08 April 2019

D2016/1529/C - RESPONSE TO COUNCIL RFI

1 NORTH ELEVATION.  
SCALE 1 : 500

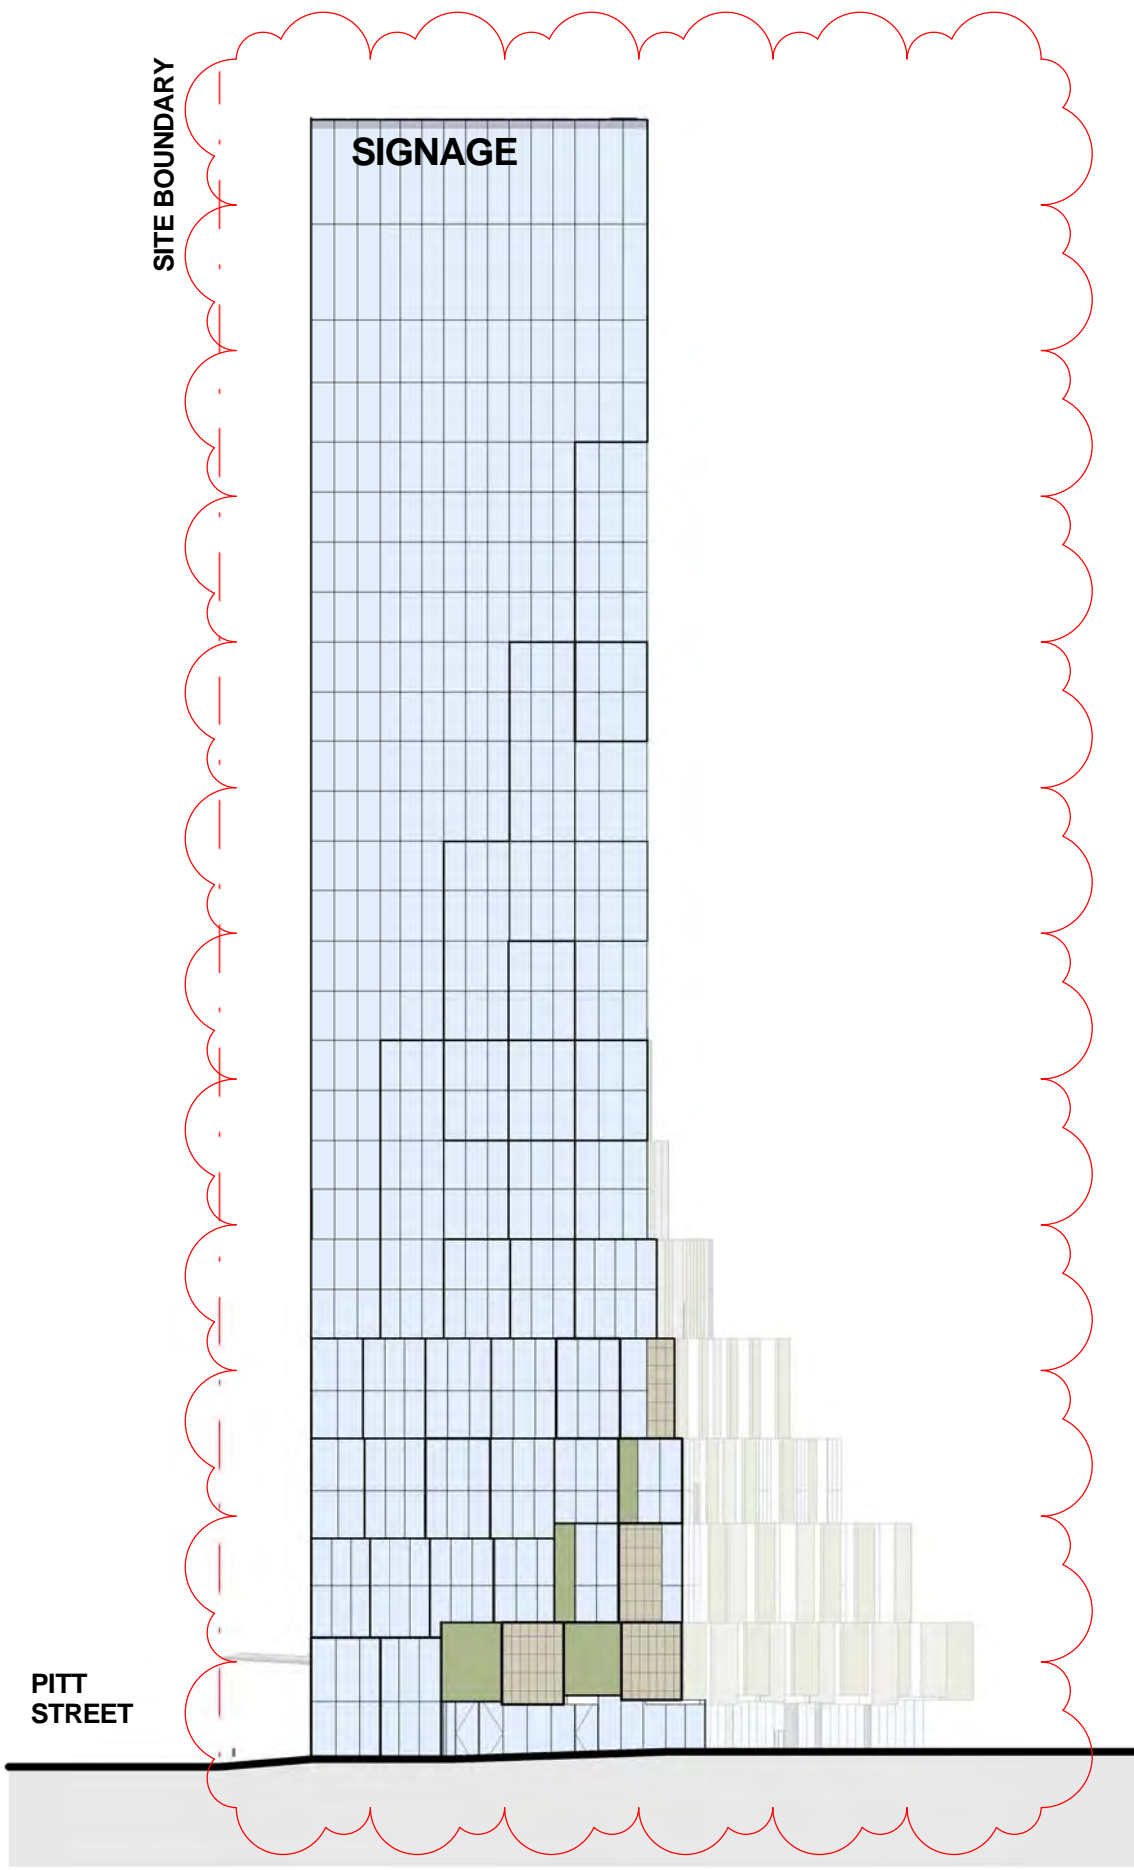
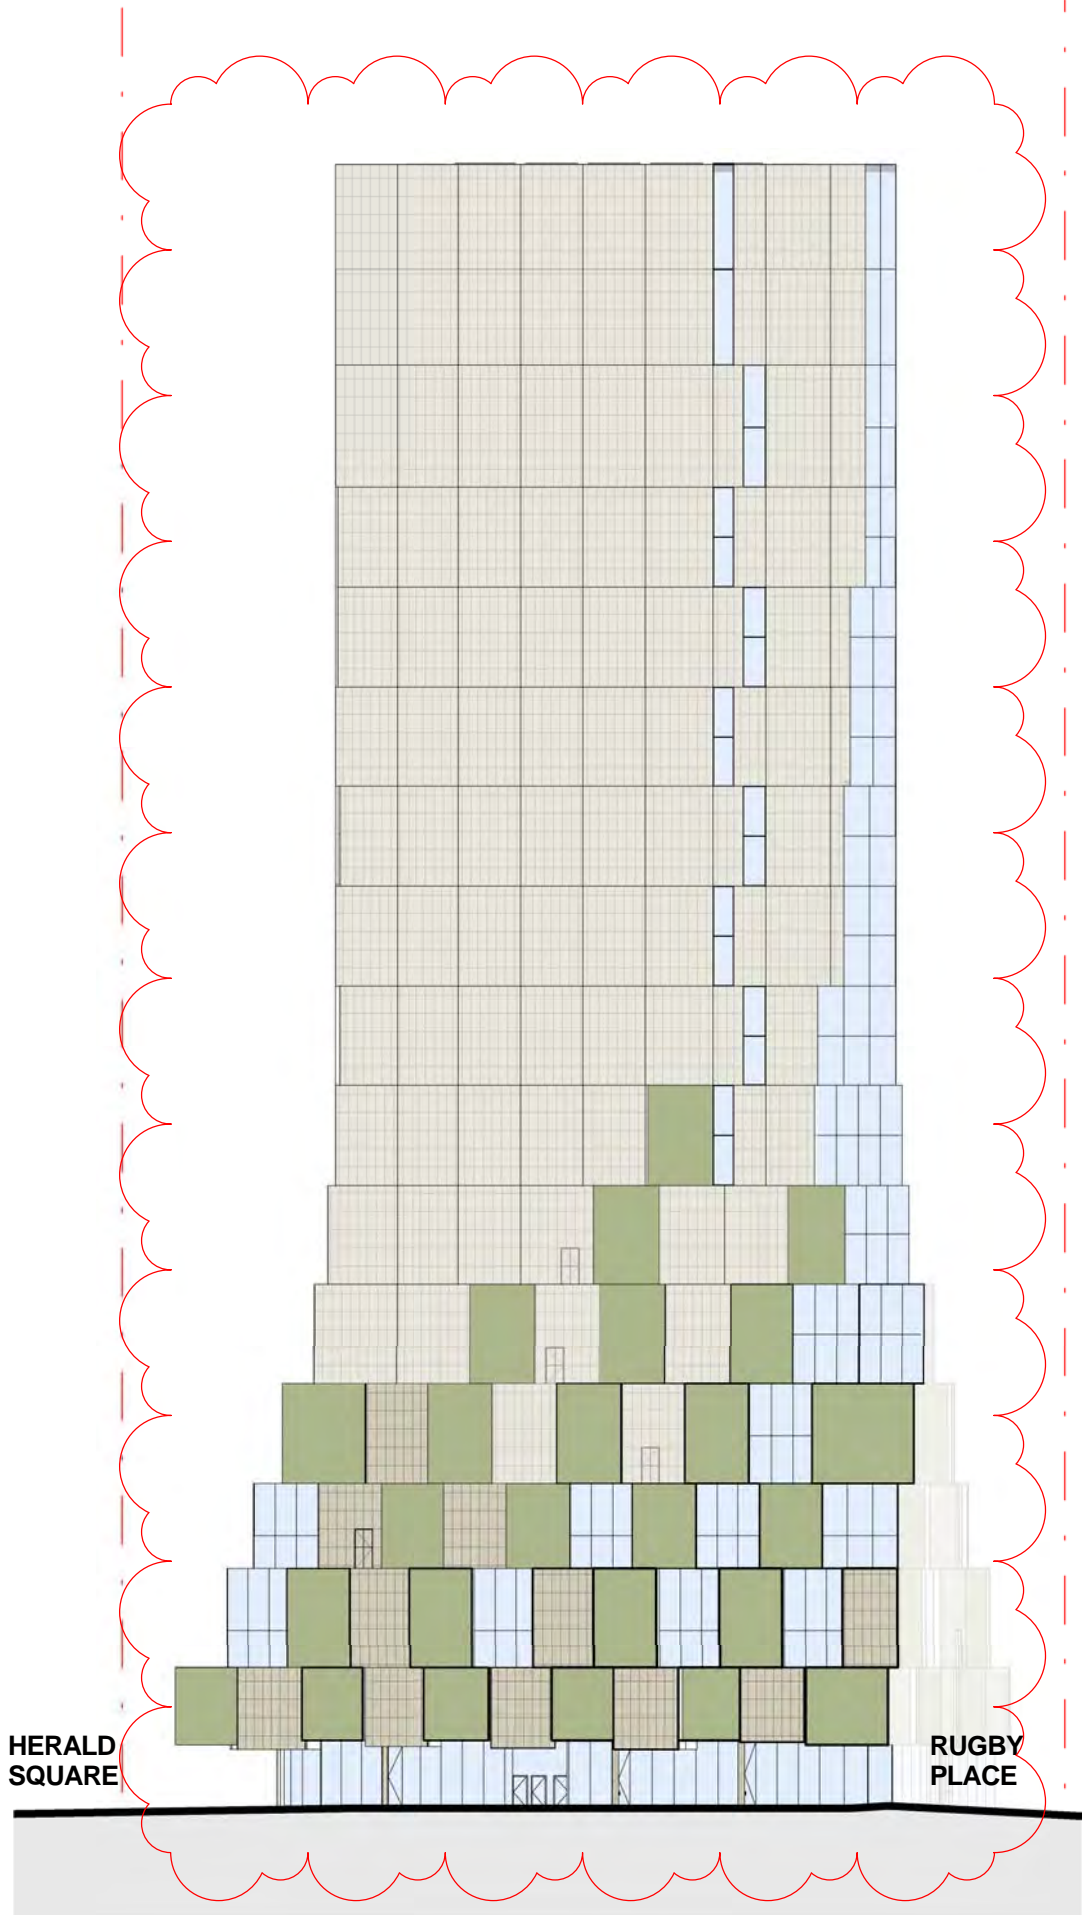
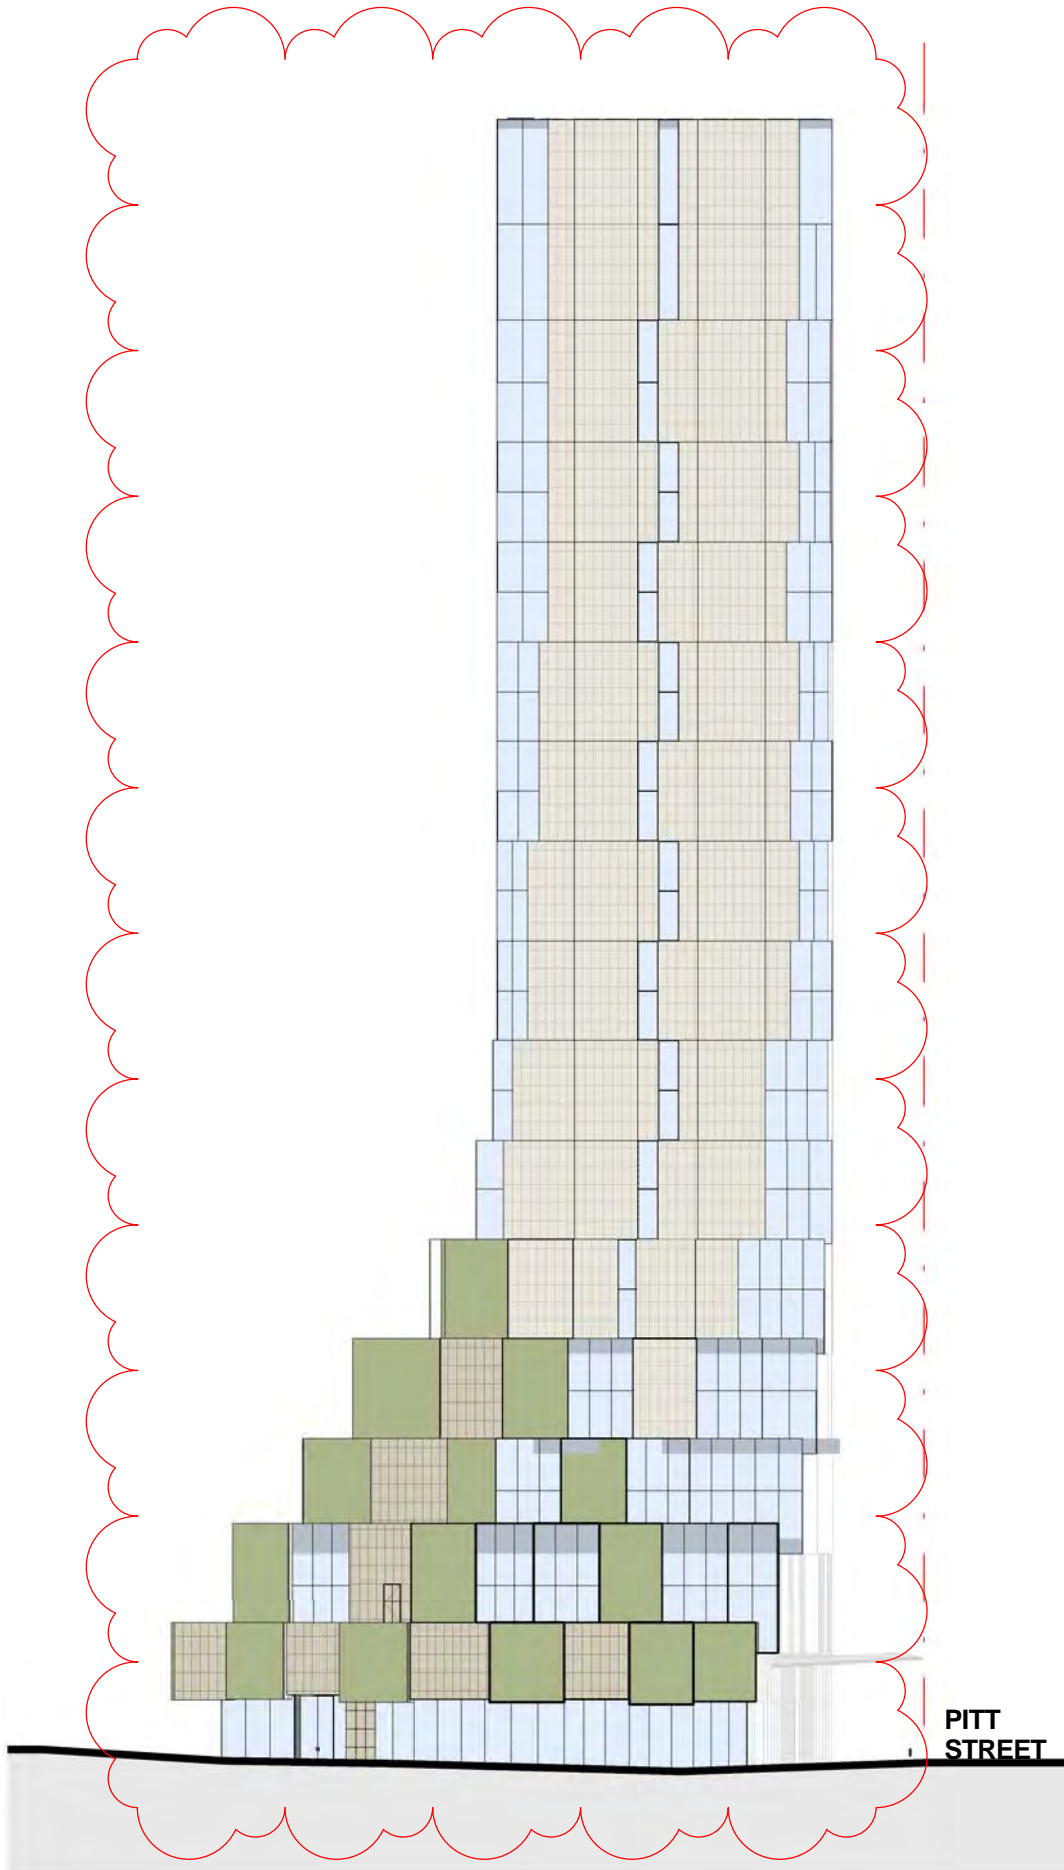
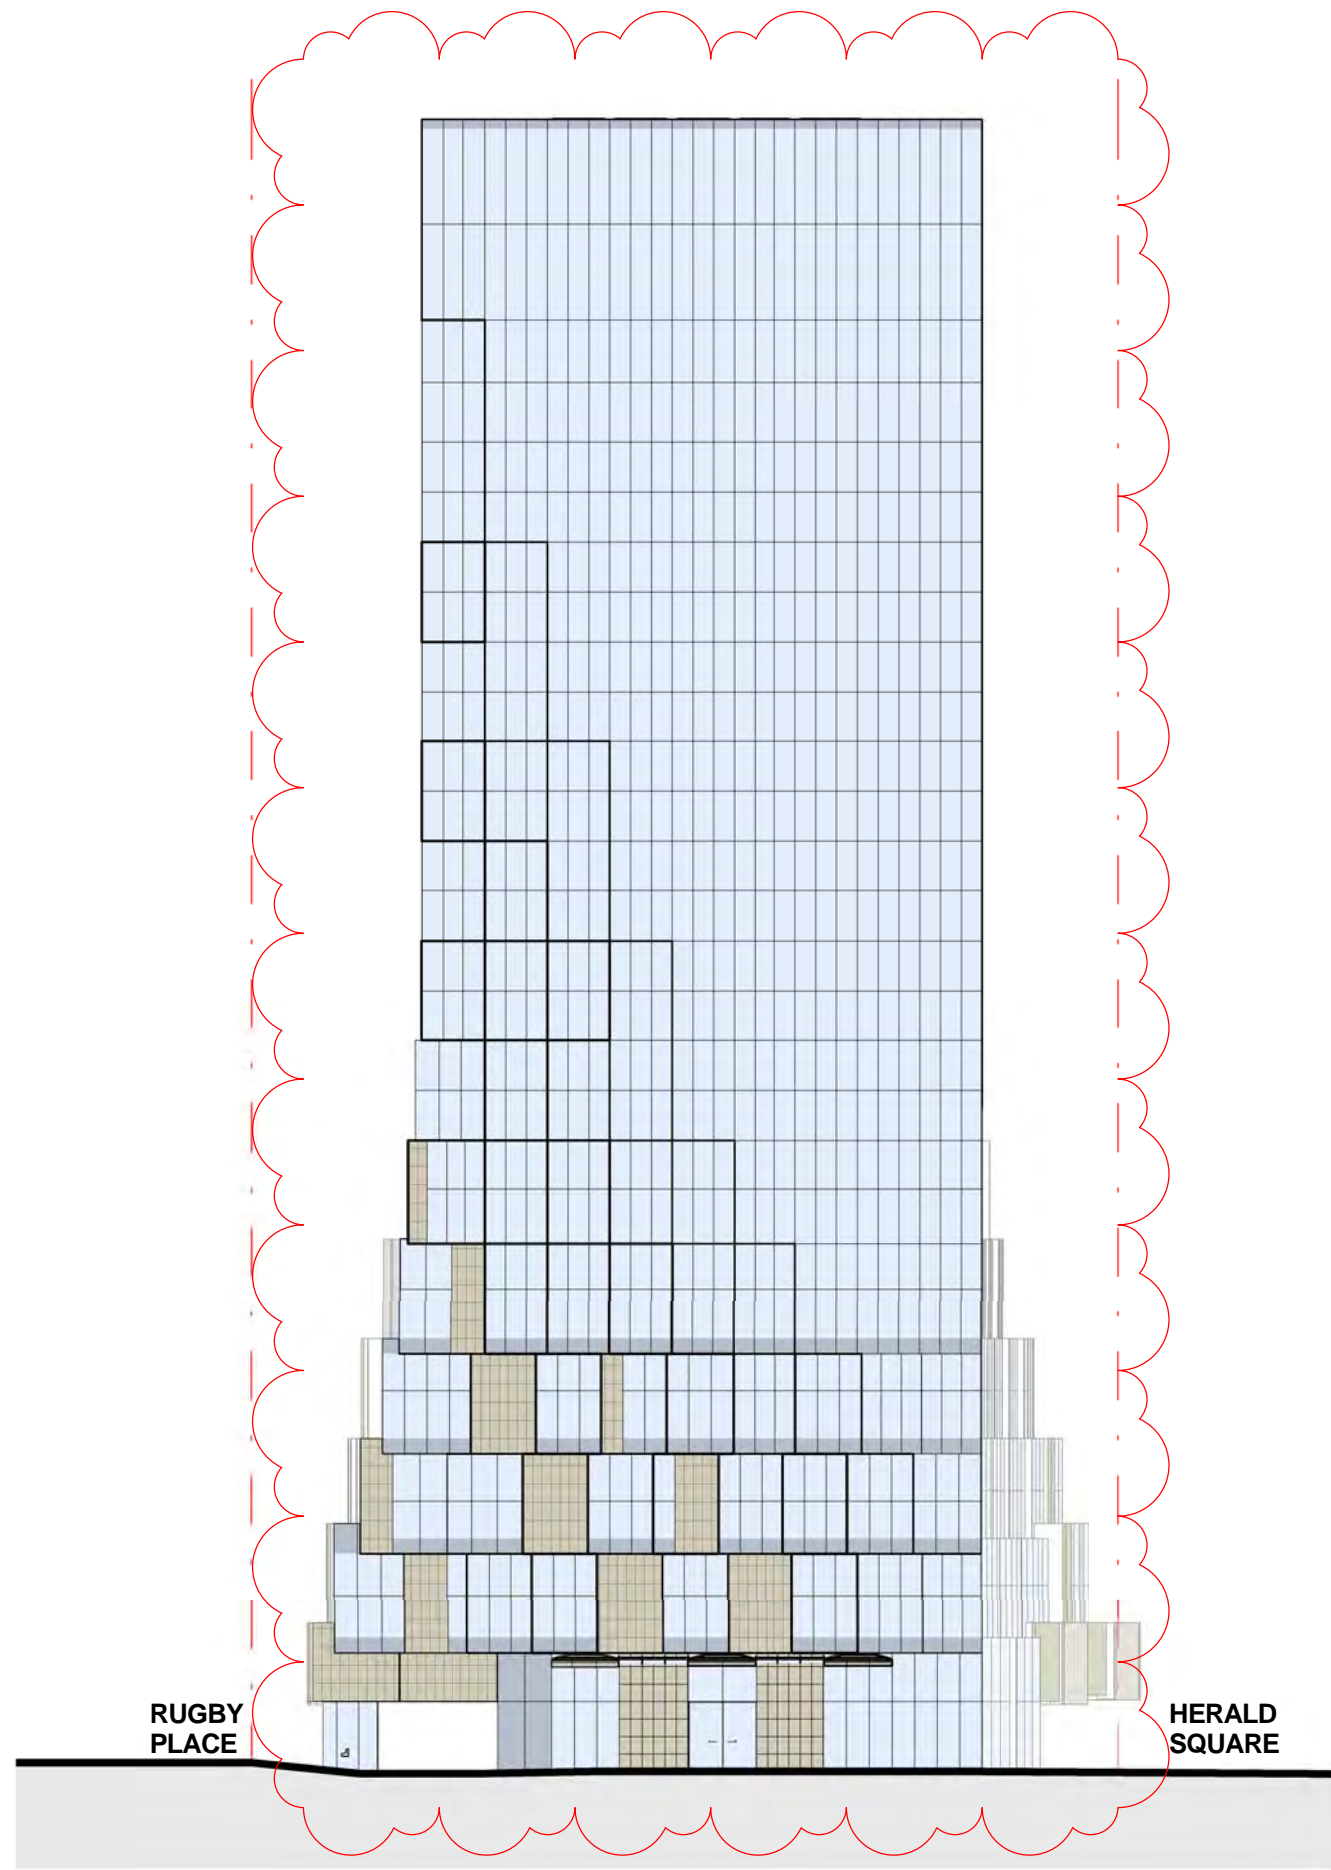
3. The plans and elevations indicate that there are areas of glazing with plant and/or voids behind but it is not clear what type or treatment to the glazing is proposed. For example, on level 1, 01 mezzanine, and Level 2 (west and south elevations). The approved glazing under Modification B is a clear type, fritted in selected locations. The elevations should be clarified accordingly.	Similar to the previous DA, only the fritted extent is annotated. For un-fritted glass used throughout the building it will be designed to maintain full expansive glass across each pixel façade module. For the previous level 5 structural transfer floor, though it also had mechanical services on the floor, the façade is perceived on the outside no different from every other floor above and below. The Architect intends to maintain this principle and avoid limiting the facade to being perceived as a back-pane. The only visible back pane of the glazing pixel is on Pitt Street ground floor beside (north) the basement entry to cover the fire stair.
